# CITY OF ALBUQUERQUE

January 8, 2019

**RE: Alameda Blvd & Barstow St.  
Drainage Report  
Engineer's Stamp Date: 12/18/18  
Hydrology File: C20D080**

This letter rescinds the approval letter dated December 18, 2018. Based upon discussions with John Mackenzie at the Engineering Division and further review, the Drainage Report **is not** approved for DRC Work Order. The following comments need to be addressed for approval of the above referenced project:

FIGURE 2. BASIN LAYOUT

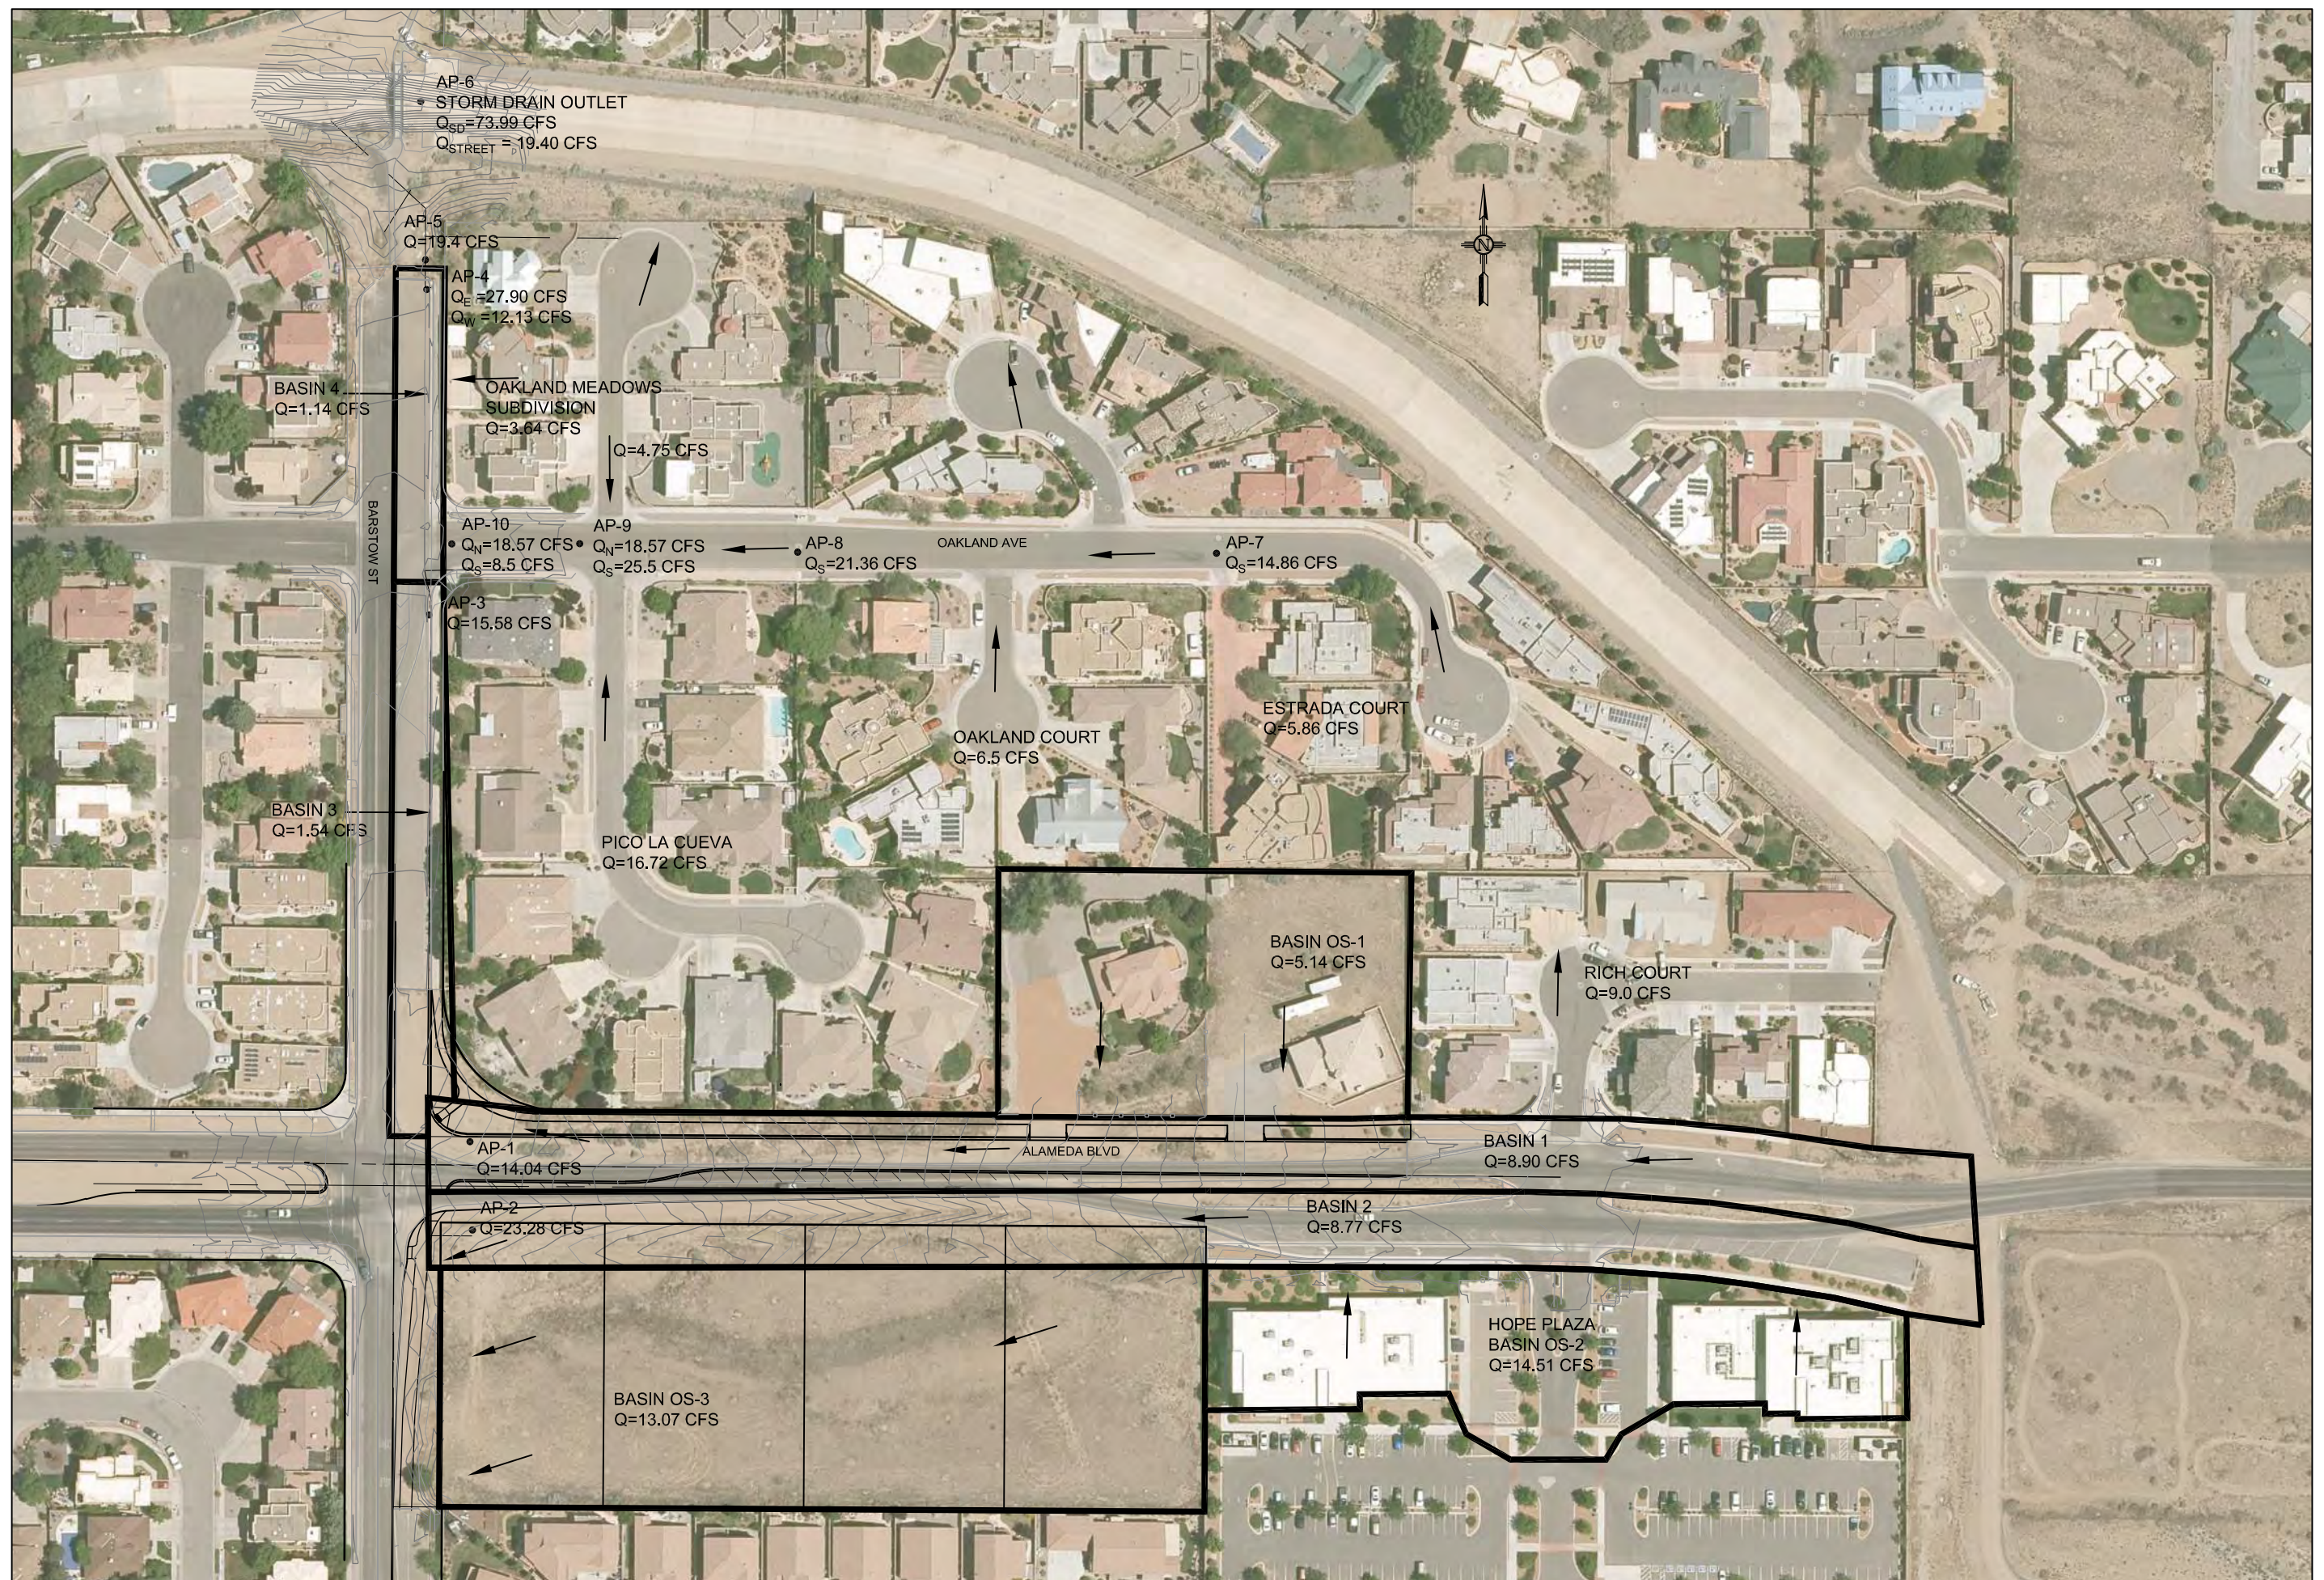
1. Please correct the statement at the top of page 4 in the drainage memo that assumes developed runoff from the vacant property on the SE corner of the intersection should drain north (in Barstow). This should state that the runoff from the vacant property on the SE corner of the intersection should drain south in Barstow.

2. Please correct the flow calculations for Basin OS-2. The weighted E method should be applied to basin OS-2, like it was applied to all the other basins, in lieu of relying on an old letter in the Hydrology file reporting on a developed flow rate. Some small reduction in flow is expected using this method.

Storm Sewer Profile

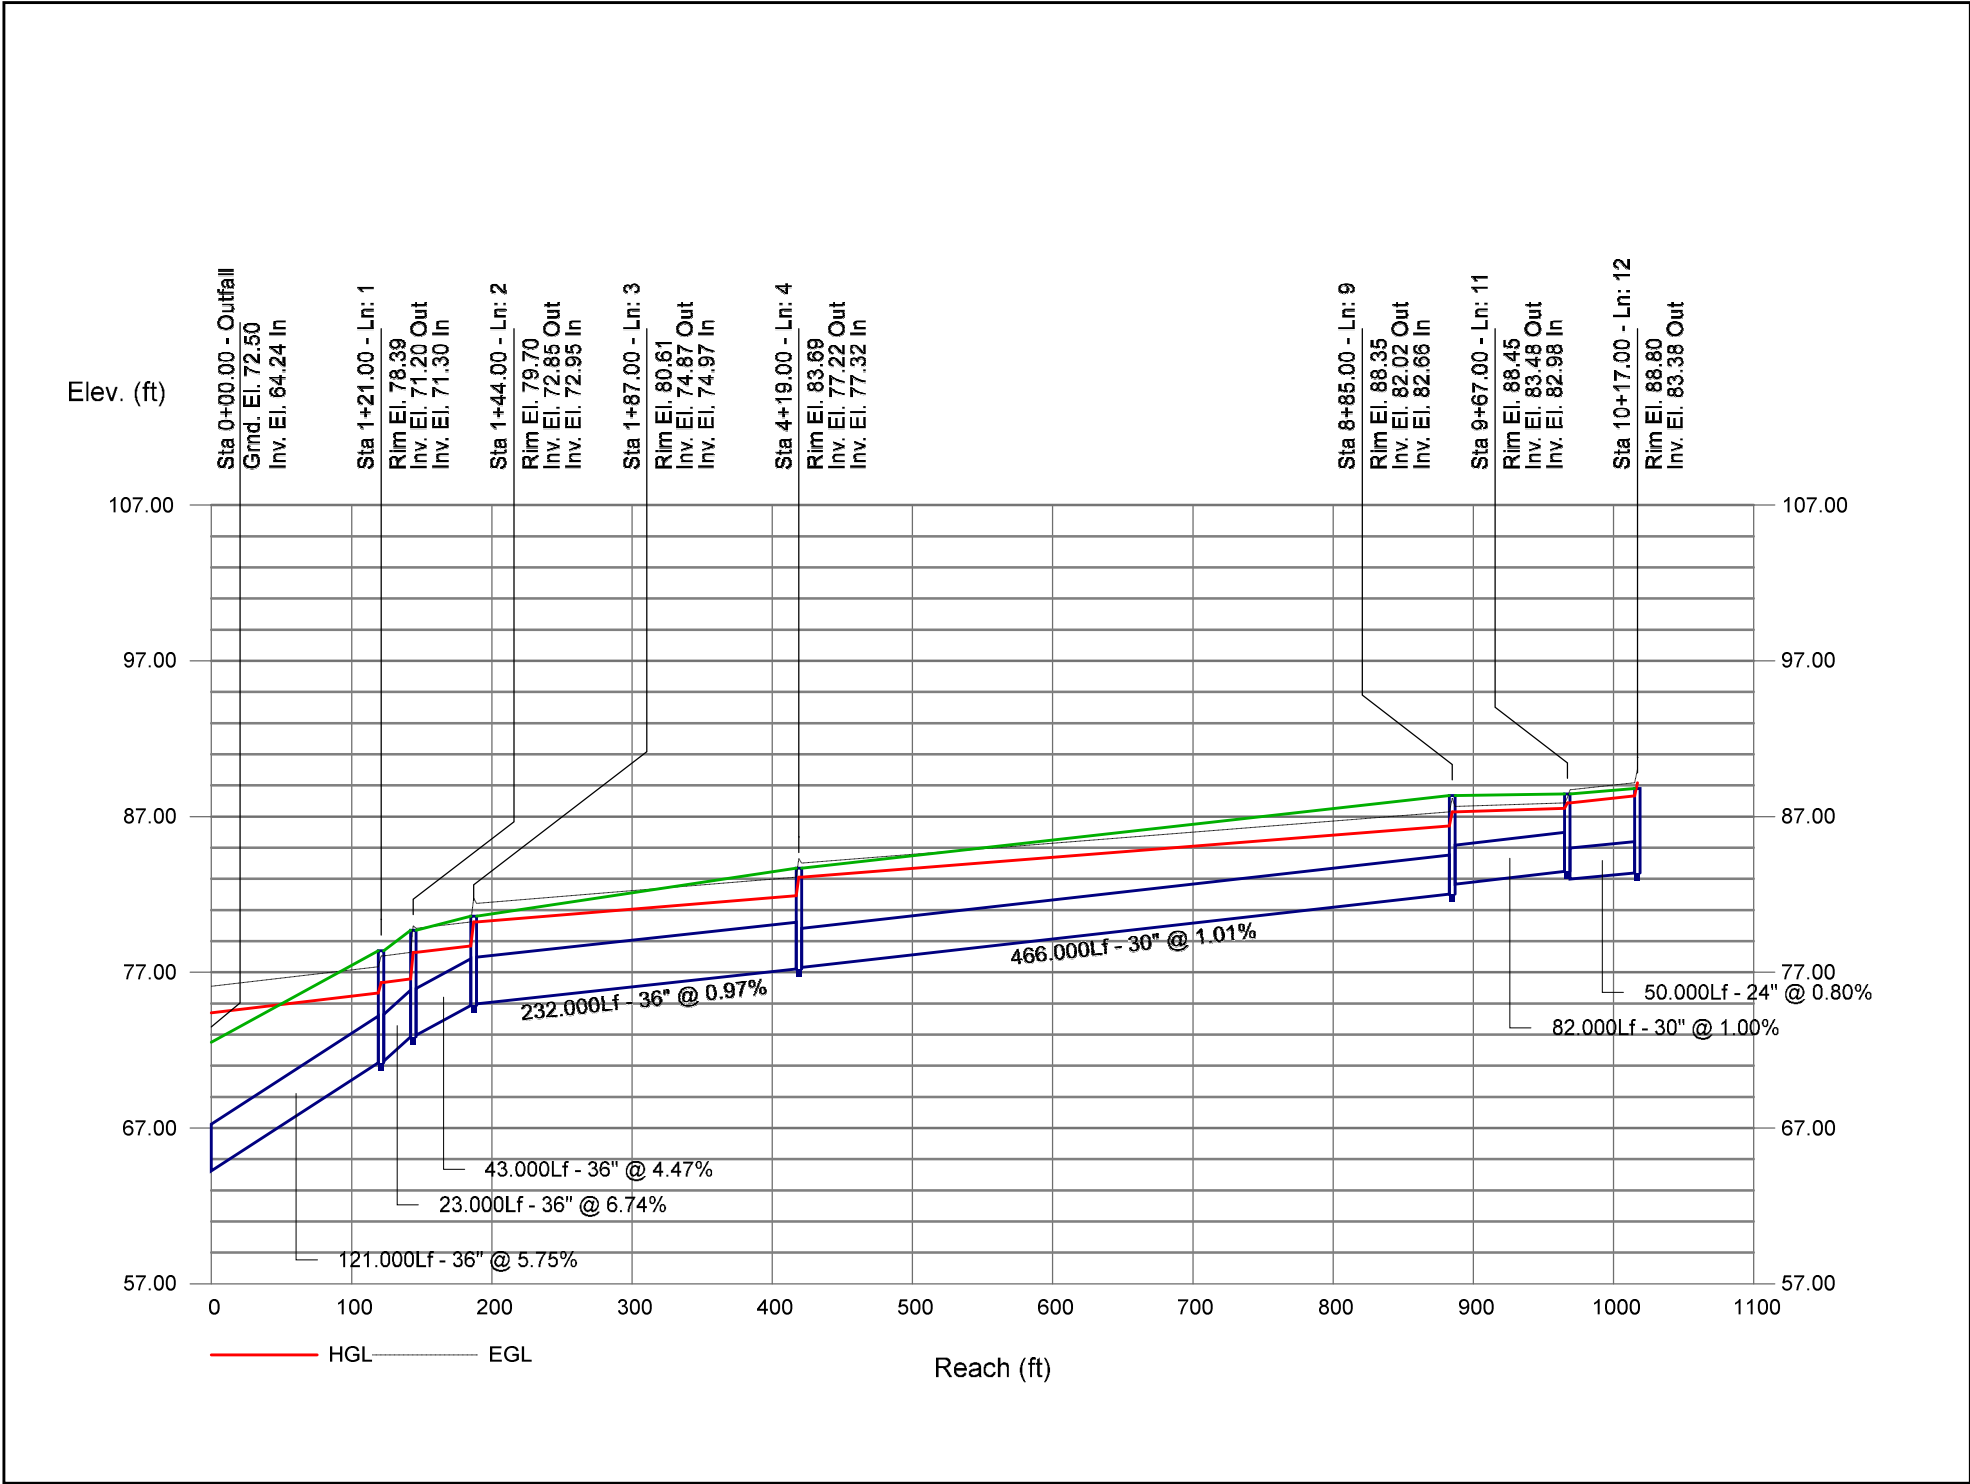
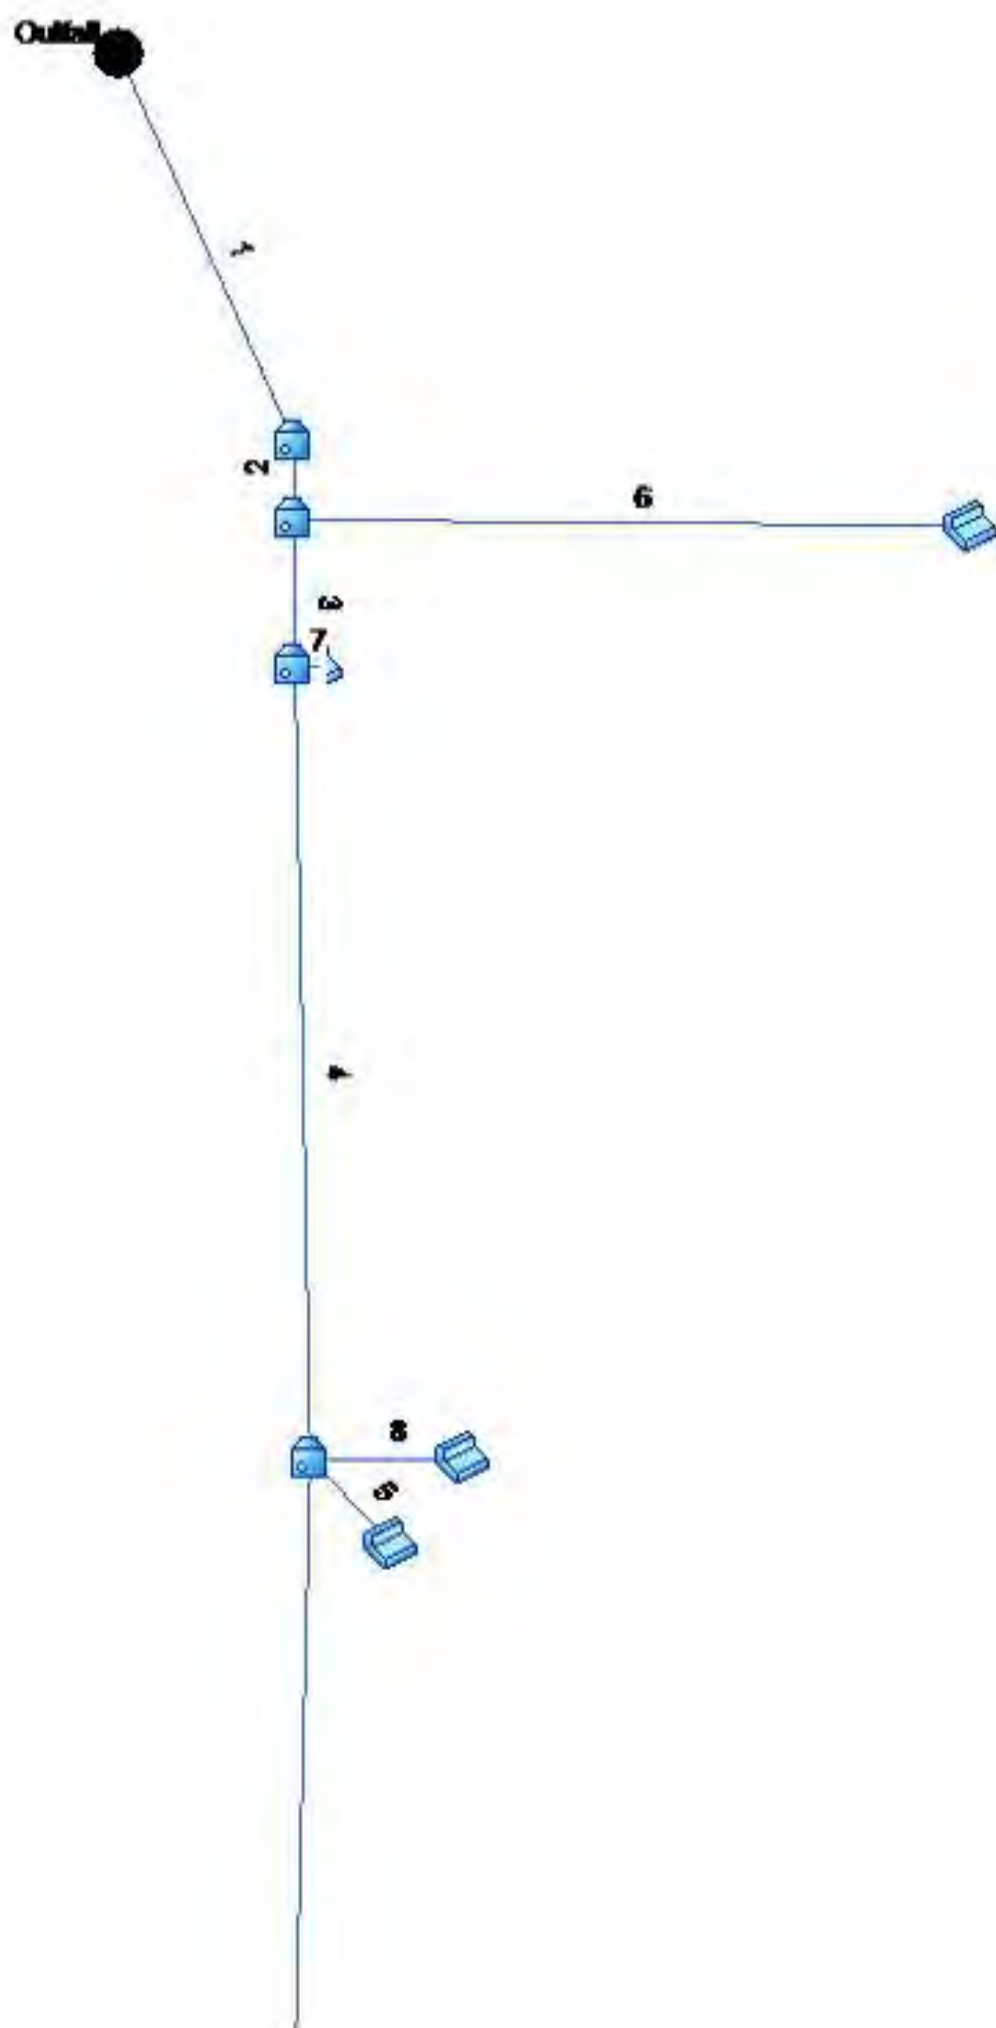
3. Please revise the pipe calculations to show the EGL elevations in the HGL calculations per the DPM.
4. Inlet capacities calculations for AP#1 and AP#2 seem to be missing from the report. Please add these calculations.
